Re: University of Newcastle Honeysuckle City Campus Stage 1A (SSD-9510) – 16 Honeysuckle Drive Newcastle

Northrop Consulting Engineers, being the civil engineering consultant for this project, provide the following comment to assist you in addressing Item 6 and 7 of the request for information from Council dated 23rd September 2019.

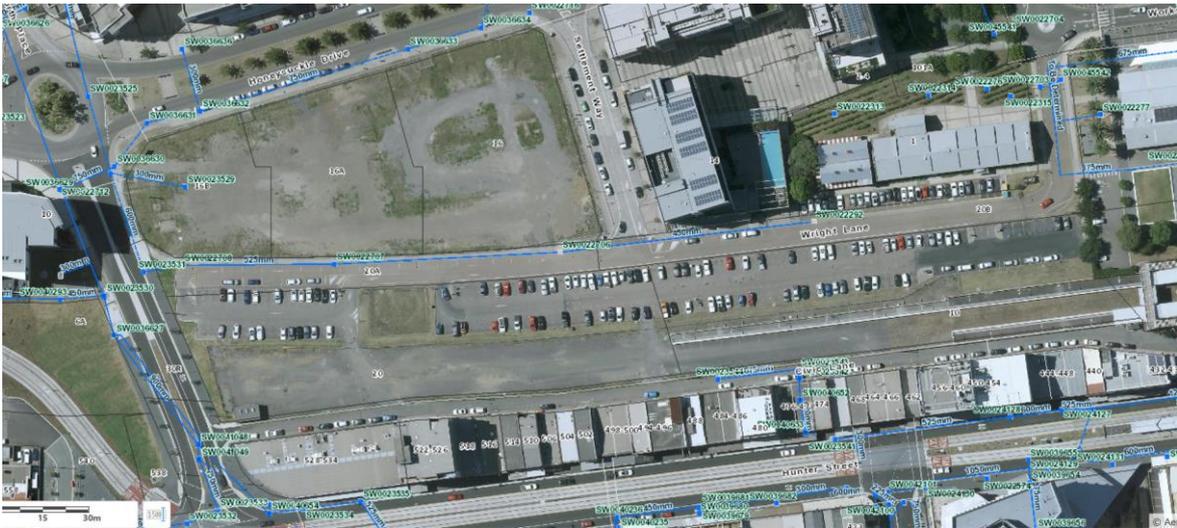
According to CN records, there are existing drainage pipes and pits along Wright Lane, which connect to Worth Place. The drainage infrastructure extends between Worth Place to Workshop Way and services the existing public road network. (See Diagram 1 below).

CN's road assets and the adjoining properties will need to be serviced through the existing pipe system. The submitted survey and subdivision plan does not indicate how the drainage system along Wright Lane will be managed.

- 1. The drainage pipe system and any additional drainage required for the city road network to be clearly indicated on the stormwater plans.
- 2. As Wright Land is owned by UoN it is assumed that the drainage pipes in the lane will remain in their ownership. In this regard, UoN are to grant legal rights to CN for draining the existing nearby public roads. Similarly, the existing private properties on the Northern side of Wright Lane will need to be granted rights to discharge stormwater to the existing drainage system in the lane. Such easements are to be created over the existing pipe in accordance with the requirements of the Newcastle Development Control Plan 2012 and legal rights for easements to be granted in accordance with the Conveyancing Act 1919.
- 3. Full CCTV dilapidation report (Pre-construction dilapidation) is be prepared for the drainage pipe and a copy provided to CN.

As noted above, works proposed under this SSD do not involve changes to Wright Lane surface levels or drainage infrastructure. Similarly, the grading to Lot 2 and 3 DP1163346 will not change the catchment to the existing drainage network. The catchment in Lot 1 DP1163346 will be detained via an onsite detention system in accordance with Aurecon design details and connected to the existing stormwater network on Worth place. Consequently, it is our opinion that, as the existing drainage infrastructure within Wright Lane will not be affected, no further investigation is required.
